**Drax Power Ltd**  
**Application by Drax Power Ltd for an Order Granting**  
**Development Consent for the Drax Re-power Project**

**Planning Inspectorate Reference:**  
**EN0100091**

**Written Representations**  
**by the Environment Agency**

**8 November 2018**

File name: \\UK.WSP.GROUP.COM\CENTRAL DATA\PROJECTS\70037047 - DRAX RE-POWERING.DOC\YORKSHIRE\CCRC\FIGURE 4_01.DWG

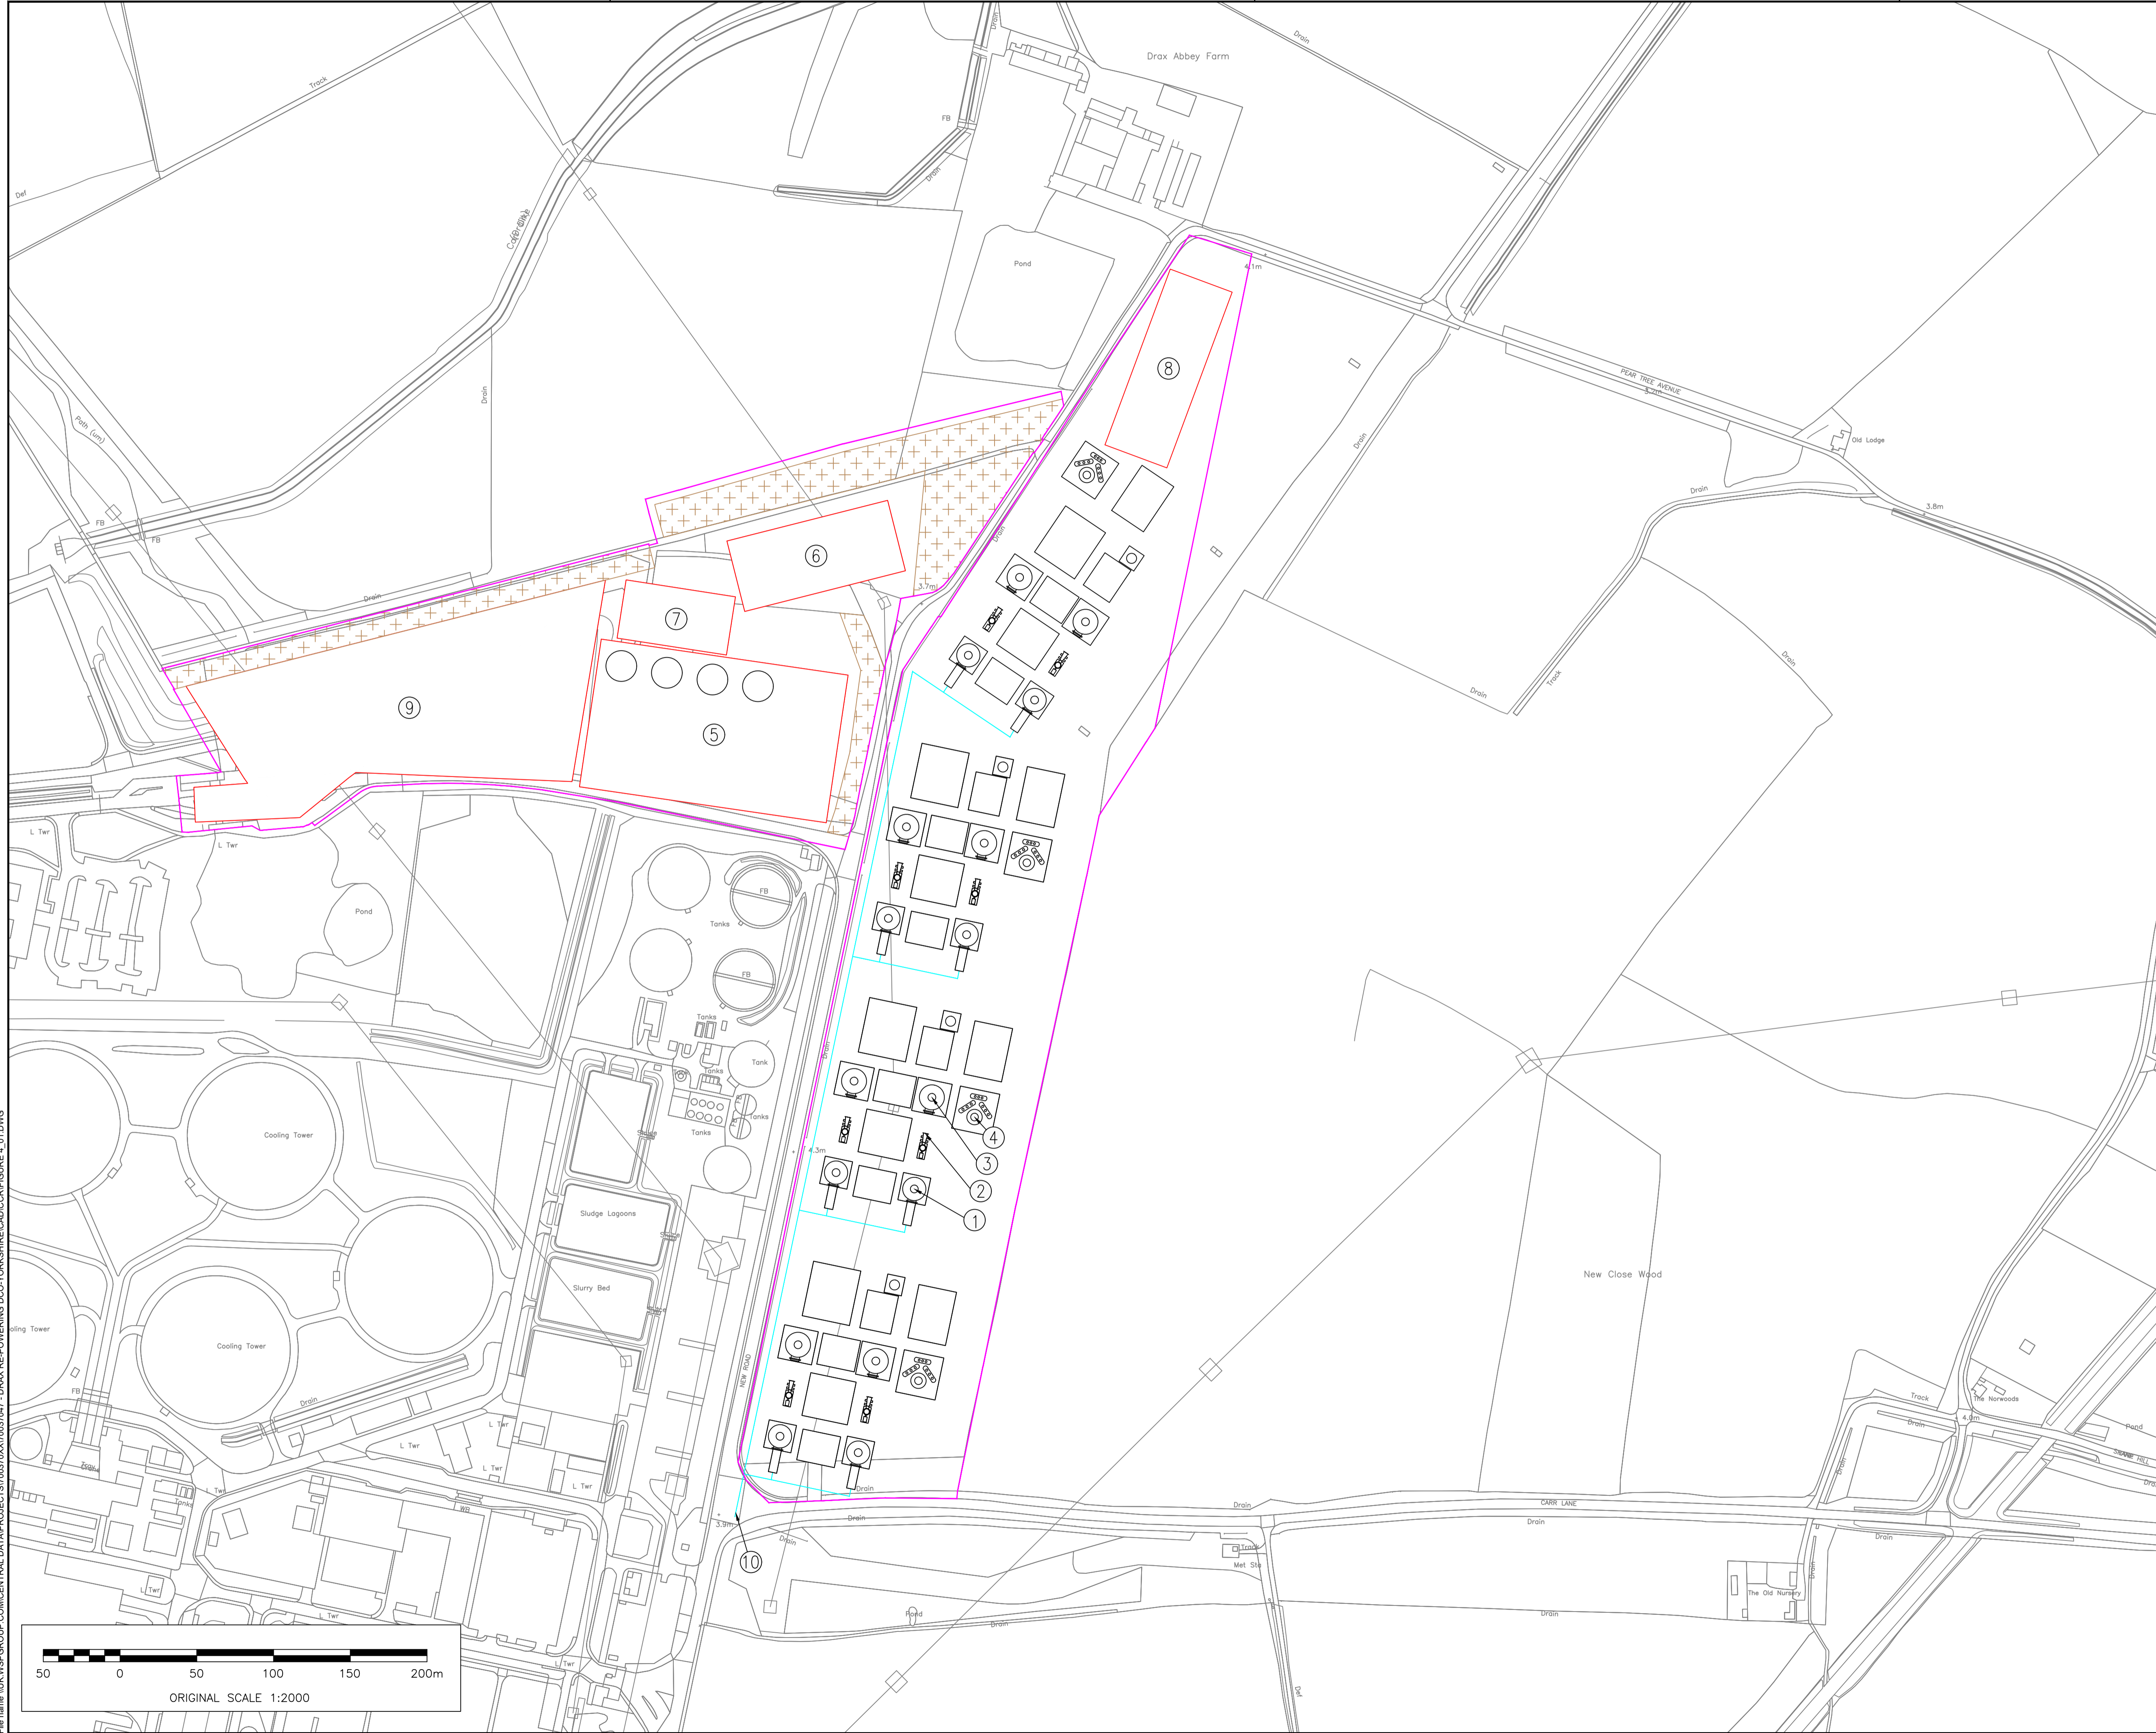
- 3.2.3 The Applicant needs to provide a statement of the estimated cooling demand for the CCP, and evidence that the area allocated in figure 4 for air cooled towers is large enough to meet this demand,

3.3 We have received information from the applicant to address the issues above. We are assessing this information and we will respond in due course.
